Appeal Decision

Appeal Ref: APP/R5510/D/17/3176808

269 Victoria Road, Ruislip, Middlesex, HA4 9DF

- The appeal is made under section 78 of the Town and Country Planning Act 1990 against a refusal to grant planning permission.
 - The appeal is made by Mr Tom Ford against the decision of the Council of the London Borough of Hillingdon.
 - The application Ref 38872/APP/2017/80, dated 19 December 2016, was refused by notice dated 13 March 2017.
 - The development proposed is described as extending crossover and parking to front garden.
-

PLAN Ref No 38872/APP/2017/80

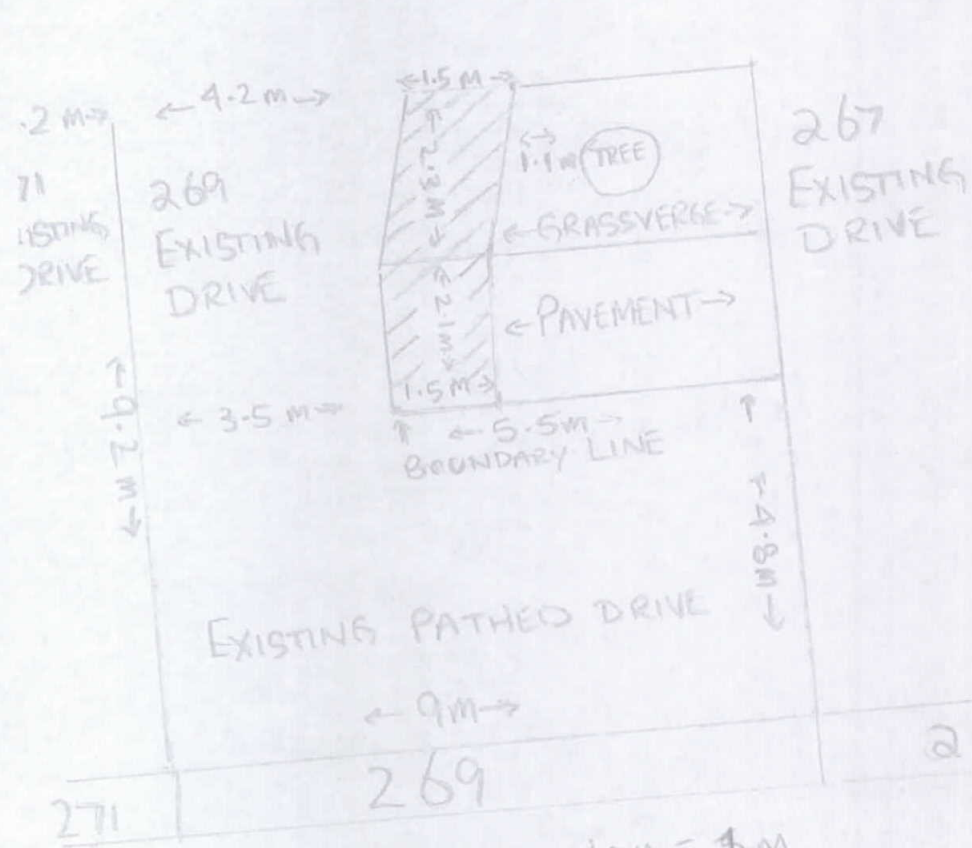
5. The proposal involves the extension of the existing crossover to the northwest by a distance of around 1.5 metres, part way across the existing verge and towards the street tree. Whilst the Council's Trees/Landscape Officer has indicated that those works would encroach on the root protection area as defined by 'NJUG guidance', the officer has not identified the extent of that root protection area. Given the limited proportions of the tree and position of the proposed works, set apart from and to one side of the tree, in my view the level of encroachment would be unlikely to be significant. Under these circumstances, I consider it unlikely that the proposed development would harm the health or stability of the tree. My finding in this regard is supported by the report of Tree Sense Arboricultural Consultants, submitted in support of the appeal. Furthermore, based on the condition of the ground, it appears likely that much of that area of verge is already routinely over-run by vehicles and there is no evidence before me to show that action would be taken to prevent such manoeuvres in the event of planning permission being withheld in this case.

7. The Council has indicated that, in conjunction with the adjoining crossover at No. 271, the proposed enlarged crossover would create an unacceptable width. However, I give little weight to the Council's assertion that the width would exceed its standing advice with regard to acceptable dimensions for crossovers, as a copy has not been provided nor its status confirmed.

8. The *Hillingdon Design and Accessibility Statement (HDAS) Supplementary Planning Document-Residential Extensions, 2008*, indicates that a wide crossover will not be acceptable where there will be a danger to pedestrians. The Council has suggested that the combined width of the adjoining crossovers at Nos. 269 and 271 would make inadequate provision for pedestrian refuge, to the detriment of pedestrian safety. However, this section of Victoria Road is straight, the front boundary of No. 269 is open and that of No. 271, insofar as it is enclosed, is bounded by a low wall. Therefore, intervisibility between drivers entering or leaving those properties and pedestrians approaching along

9. The Council has indicated that the provision of 3 parking spaces at the front of No. 269 would be contrary to UDP Policy AM14, as the Council's parking standards indicate that 2 spaces should be allocated per dwelling. However, as the hardstanding at the front of the appeal site already has capacity for 3 cars to park and there is no evidence to show that the area would be likely to be reduced in the event of dismissal of this appeal, I give little weight to that Policy conflict. To my mind, the proposed crossover would ease access to the northwestern section of the parking area, making it less likely that vehicles would have to manoeuvre back and forth to park, which might otherwise increase the risk of them coming into conflict with passing pedestrians.

1. The appeal is allowed and planning permission is granted for extending crossover and parking to front garden at 269 Victoria Road, Ruislip, Middlesex, HA4 9DF in accordance with the terms of the application, Ref 38872/APP/2017/80, dated 19 December 2016, subject to the following conditions:
 - 1) The development hereby permitted shall begin not later than 3 years from the date of this decision.
 - 2) The development hereby permitted shall be carried out in accordance with the approved plans, identified by the Council as: *Location Plan (1:1250)-received 18 Jan 2017*; and, *Proposed site layout-received 18 Jan 2017*.
 - 3) The external surface of the development hereby permitted shall be constructed in the materials matching those of the existing crossover.

12. The Council has suggested 3 conditions, which it considers should be imposed in the event of planning permission being granted. In addition to the normal commencement condition, a condition would be necessary, in the interests of certainty, to ensure that the works would be carried out in accordance with the approved application plans. Furthermore, in the interests of visual amenity, a condition would be necessary to ensure that the materials used in the external surface of the development would match those of the existing crossover.
